RE: Lot #2 Ballpark Drive – 371-A-032 - R-2 Zone – application #05-1010

RE: Application for Single Family House, Ball Park Drive, Lot 2, ID # 2005-0170

Upon review of the site plan, the City's Planning Division has the following comments:

SITE PLAN
OF
LOT 2 BALLPARK DRIVE, PORTLAND, MAINE
MADE FOR
ANTHONY ORLANDO
57 SHEPHERD LANE, PORTLAND, MAINE

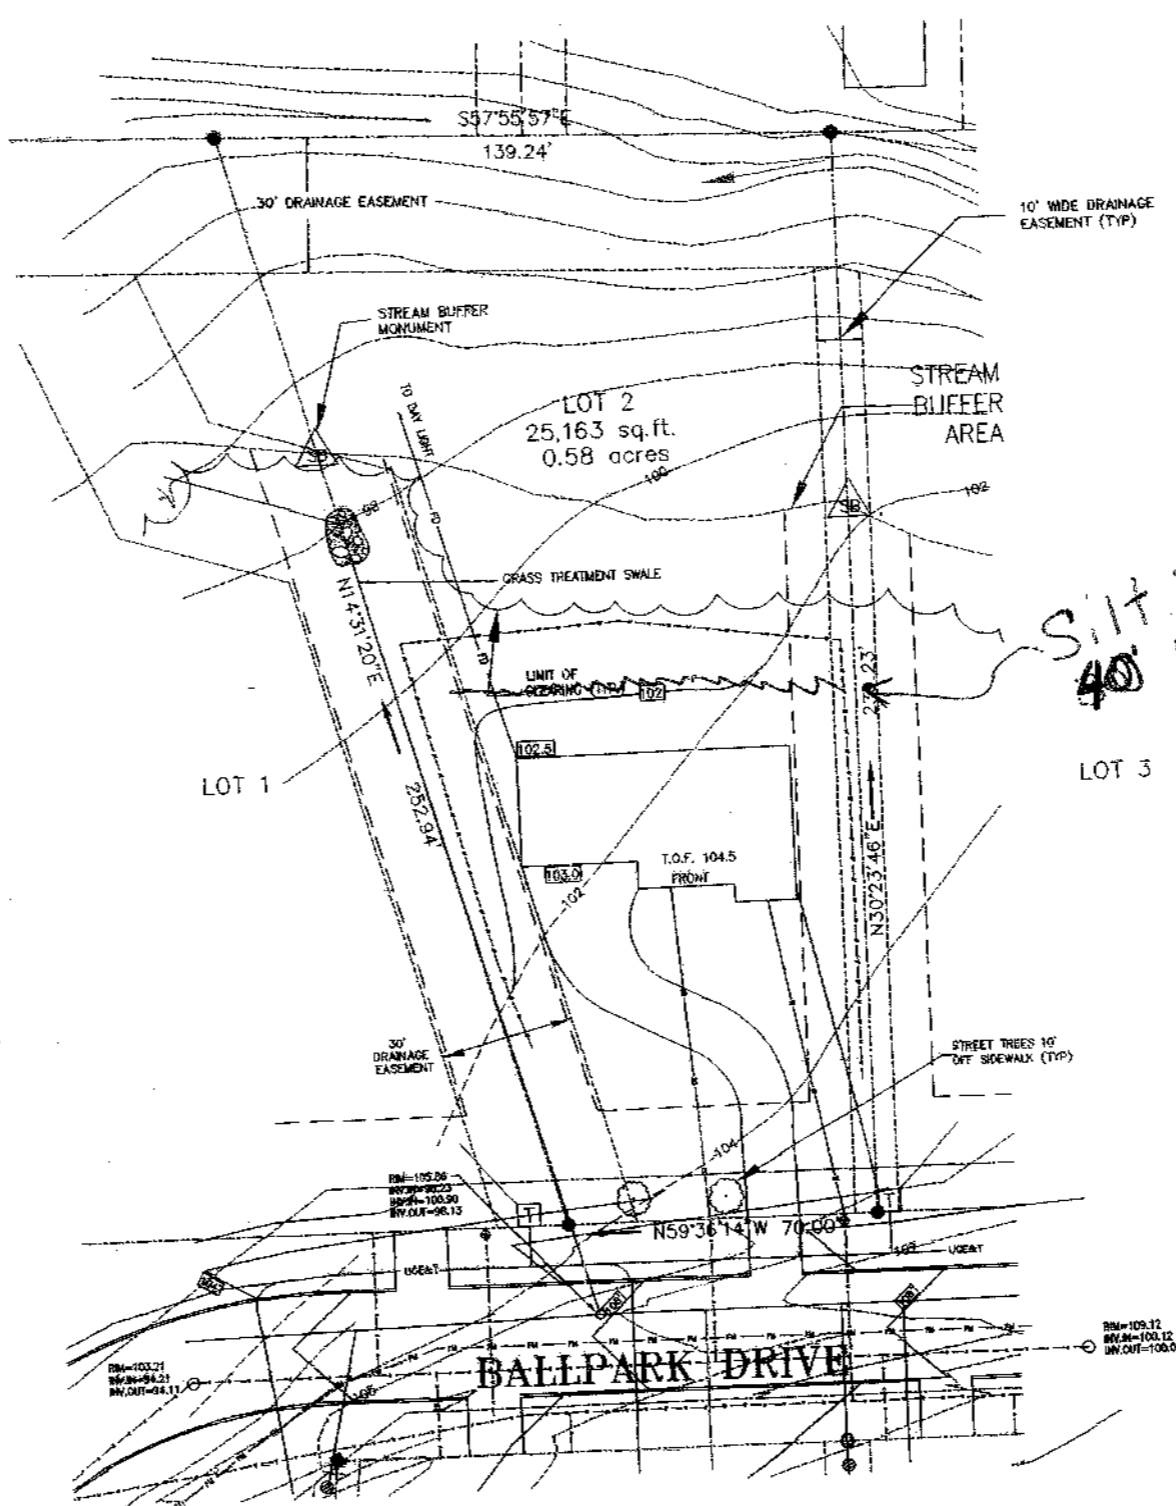
1. There is a 10' easement on your site plan that was not part of the Ball Park Subdivision. Please elaborate.
2. Please remove the foundation drain that falls within the stream buffer limit.
3. A sewer cleanout is required on sewer services greater than 80 feet from the sewer main. Please add a cleanout to the plan.
4. Reduced size/copy of site plan was not to-scale.
